FINAL DRAINAGE REPORT

Foundation Lutheran Church

Towners Ave
Tract C, Paint Brush Hills Filing No. 13A
Falcon, Colorado

October 17, 2023

DESIGN POINT	FLOW (CFS)
EP1	Q <sub>5</sub> = 1.37 Q <sub>100</sub> = 10.05
EP2	Q <sub>5</sub> = 11 Q <sub>100</sub> = 21

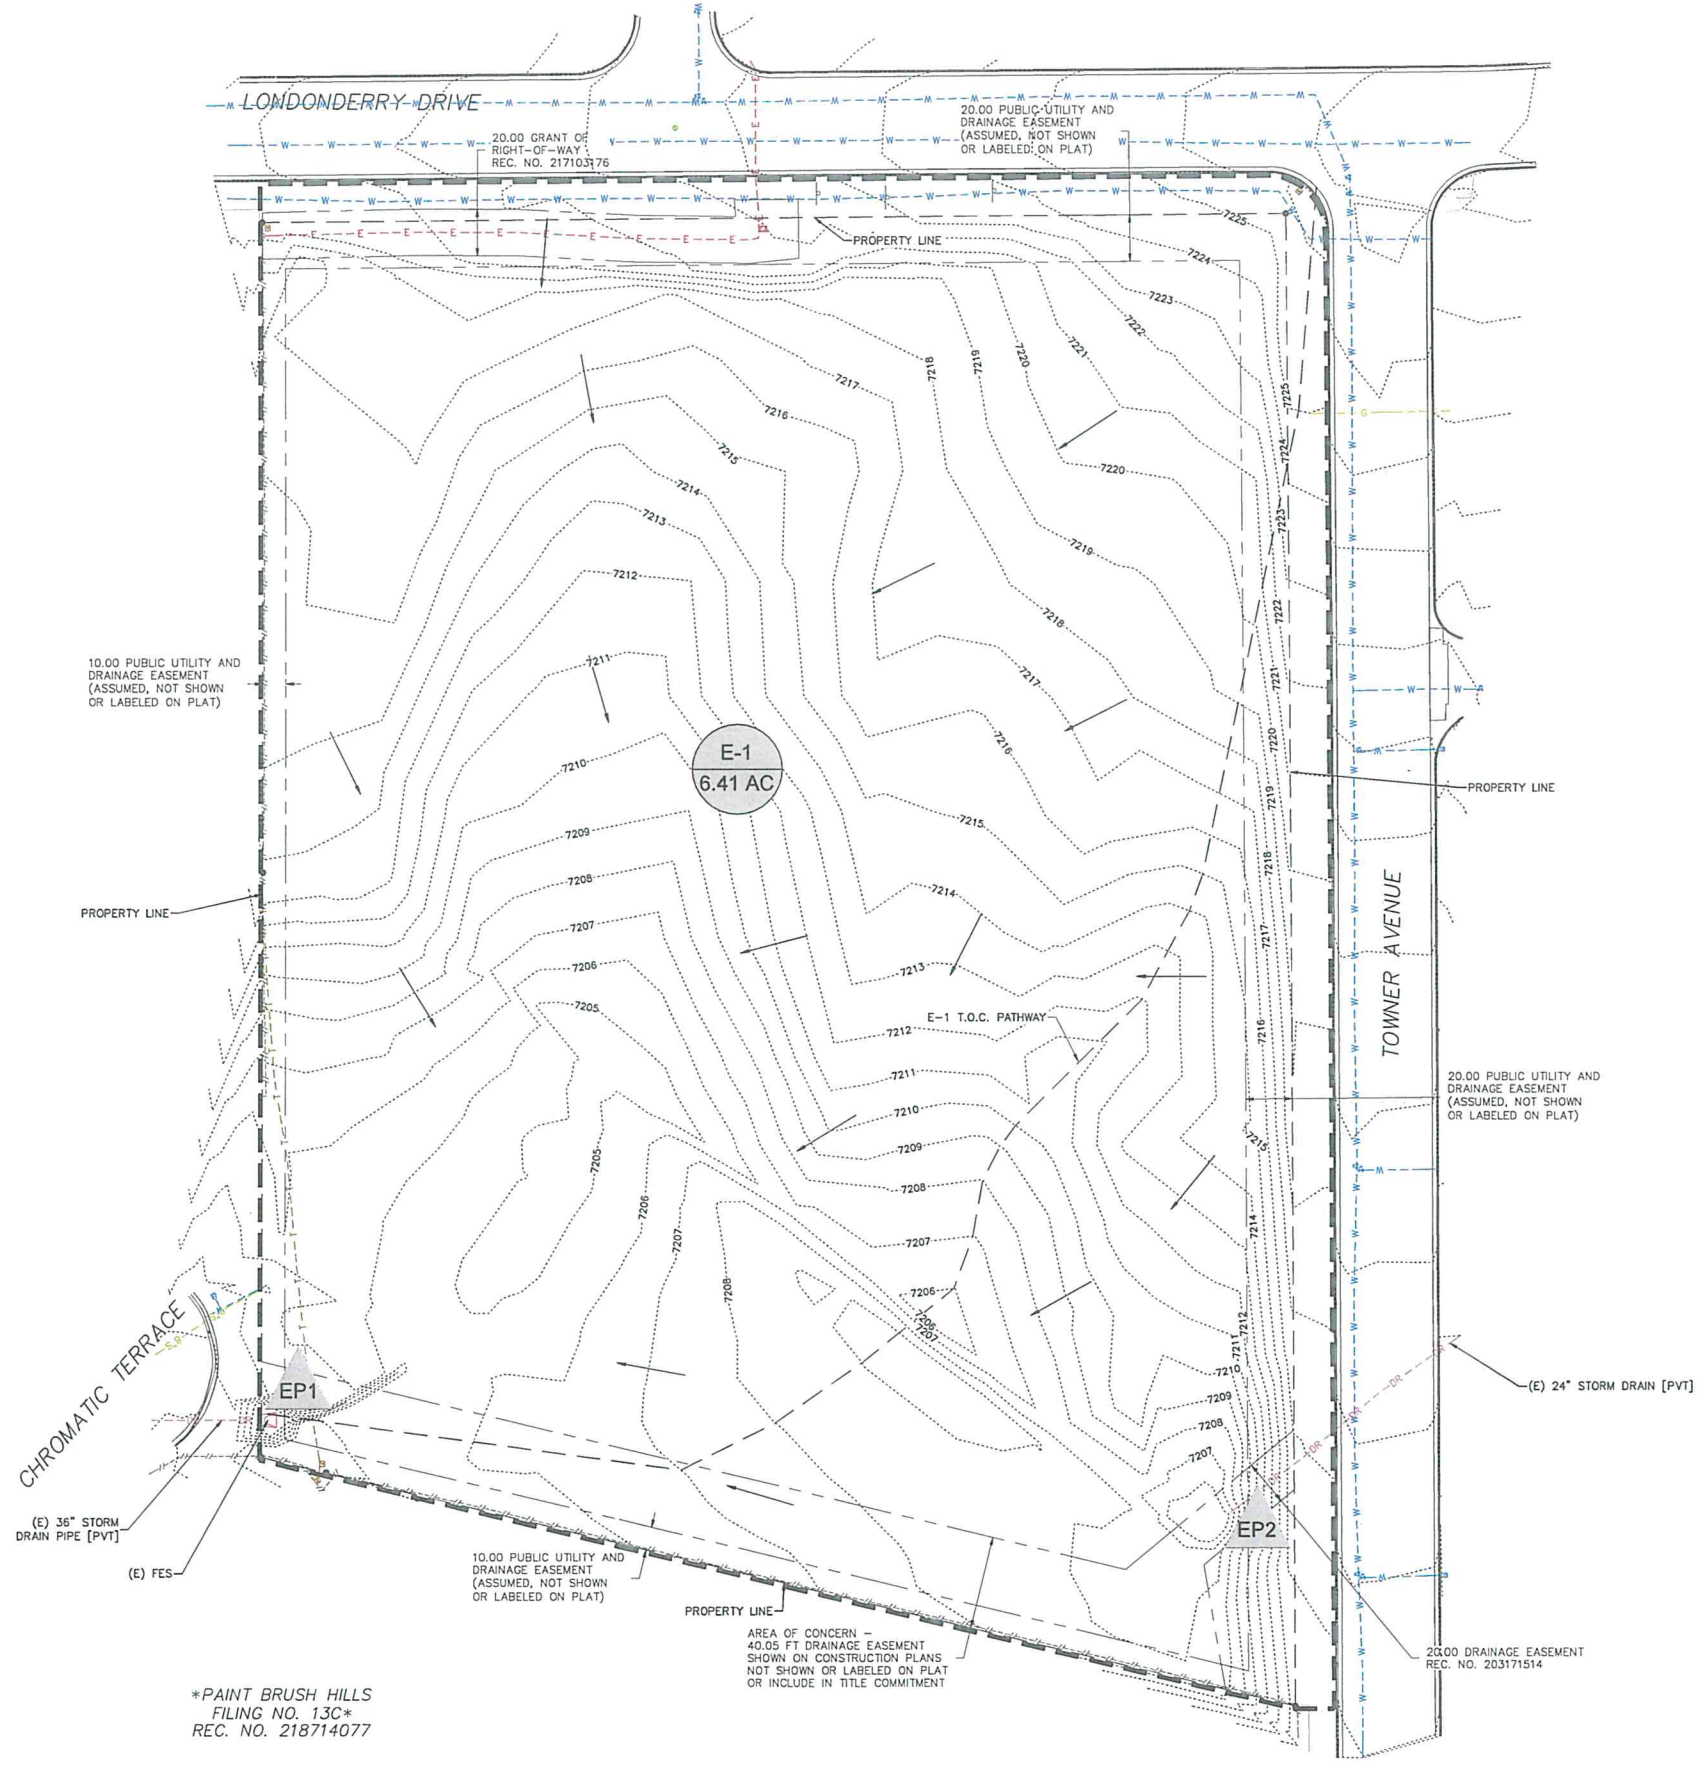
Unresolved Review 1 Comment:
- Please discuss any off-site flows entering the site and impacts to the development. If there are none please state so.

DP3 RMG= DP11 CLASSIC CONSULTING ENGINEERS & SURVEYORS

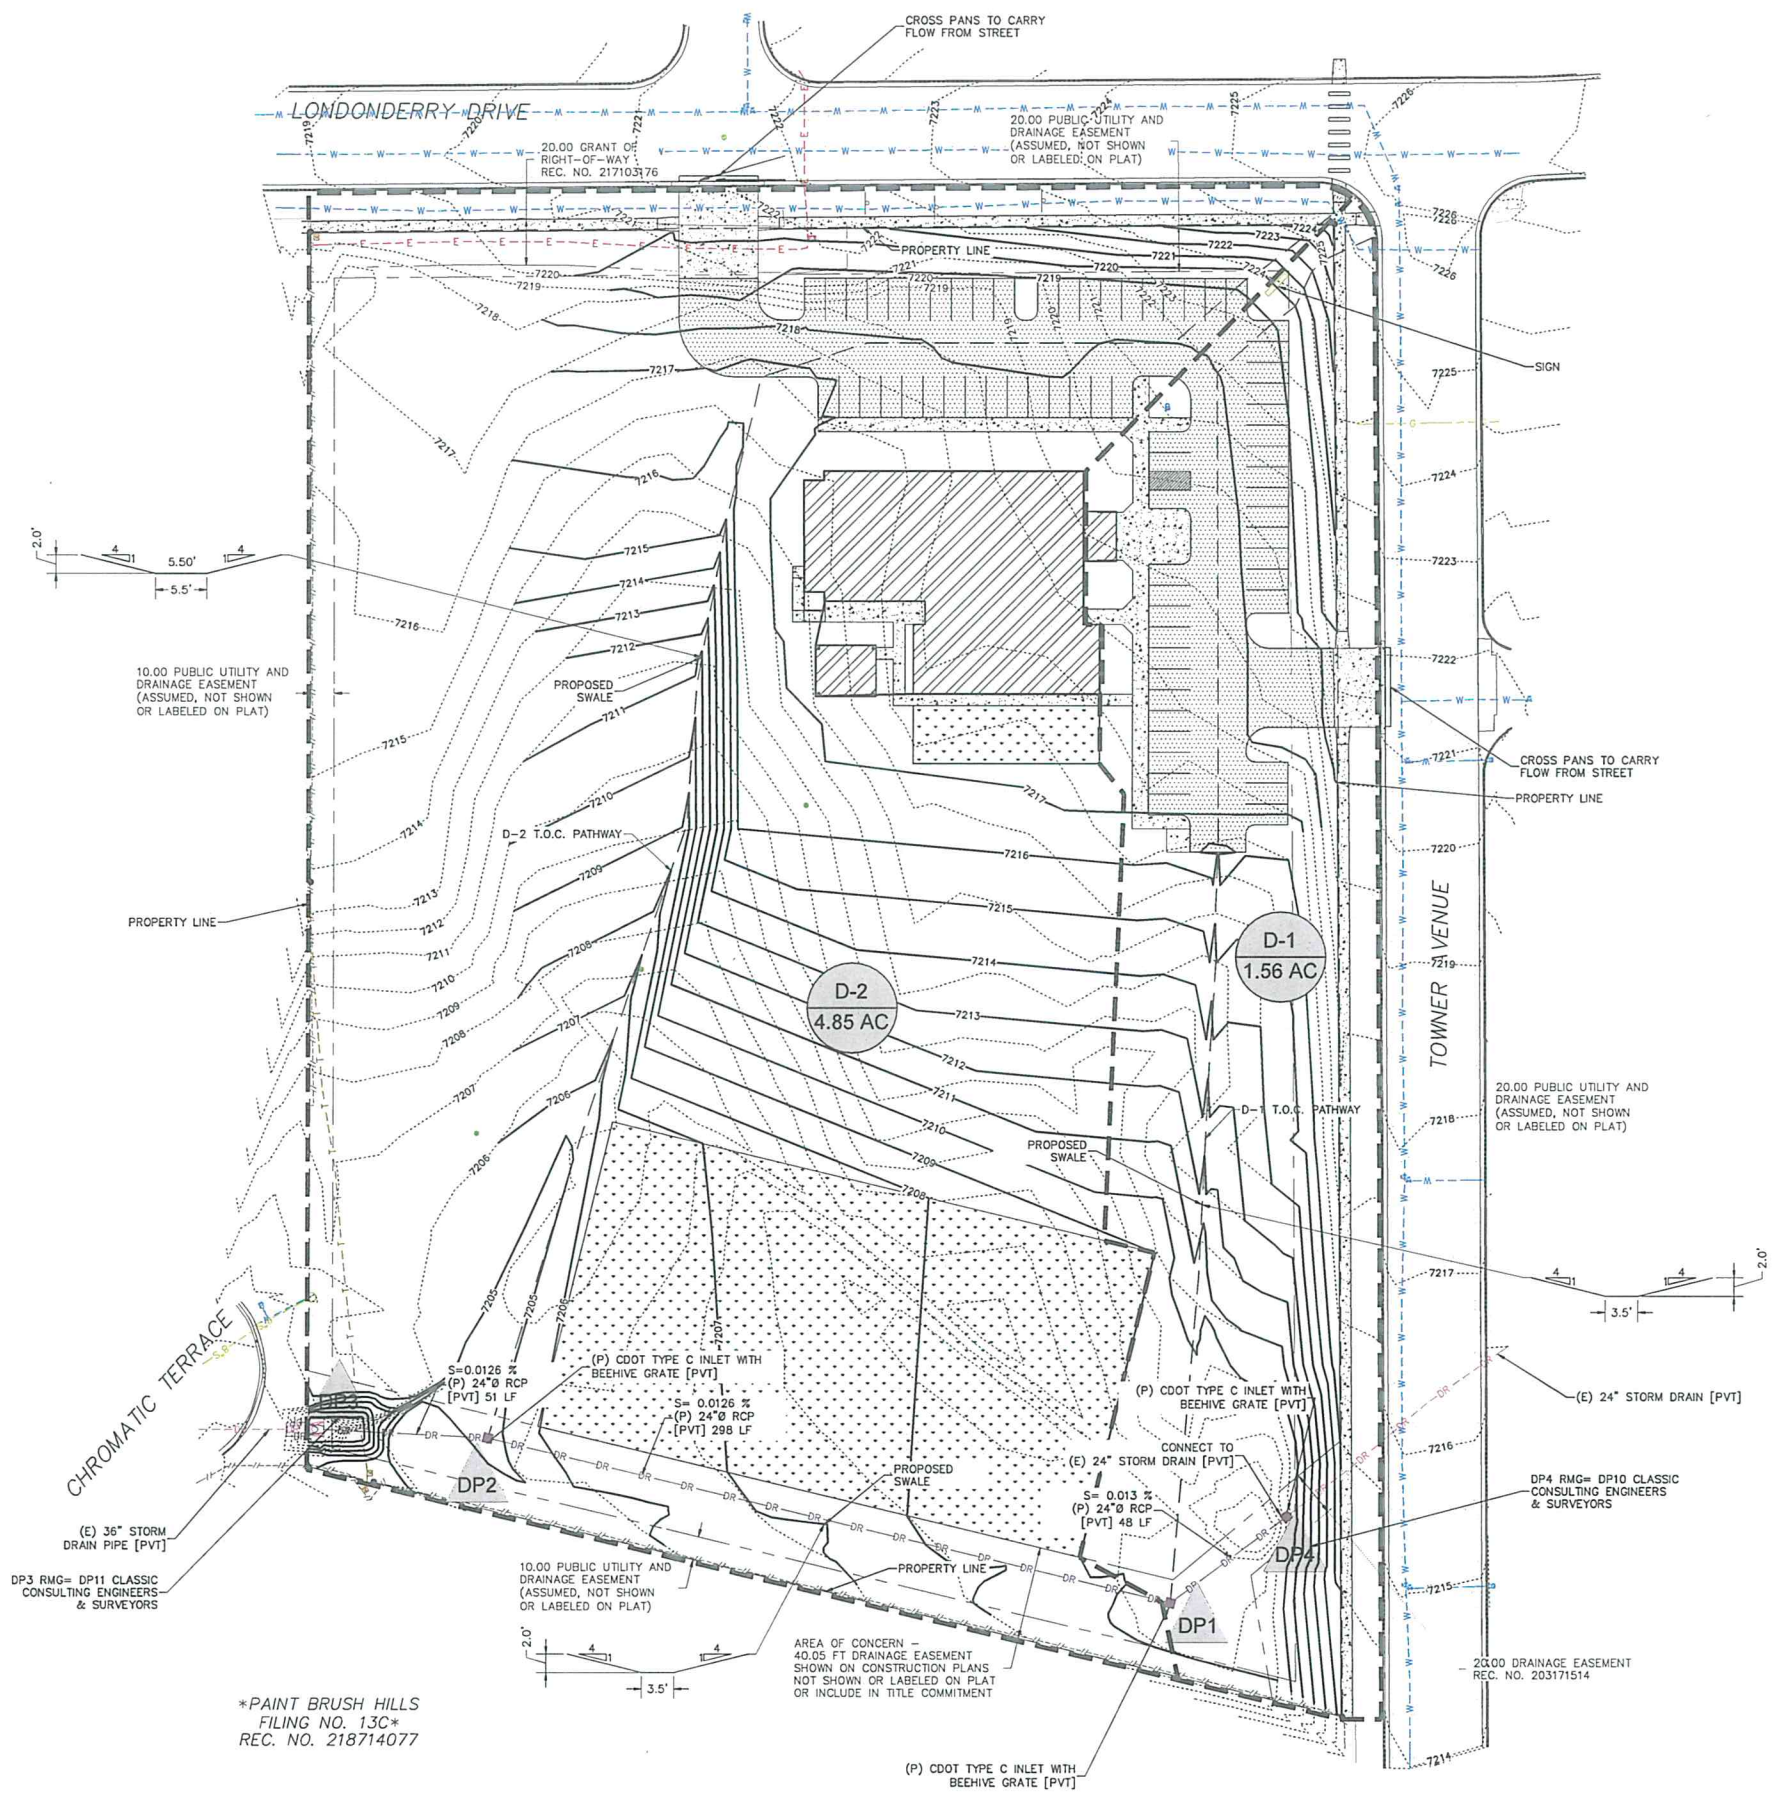
**Show and label on the drainage map where DP10 and DP11 are located.
Or provide drainage map from previously approved report in the appendix.**

Please verify runoff values shown match with the values shown on the drainage map.
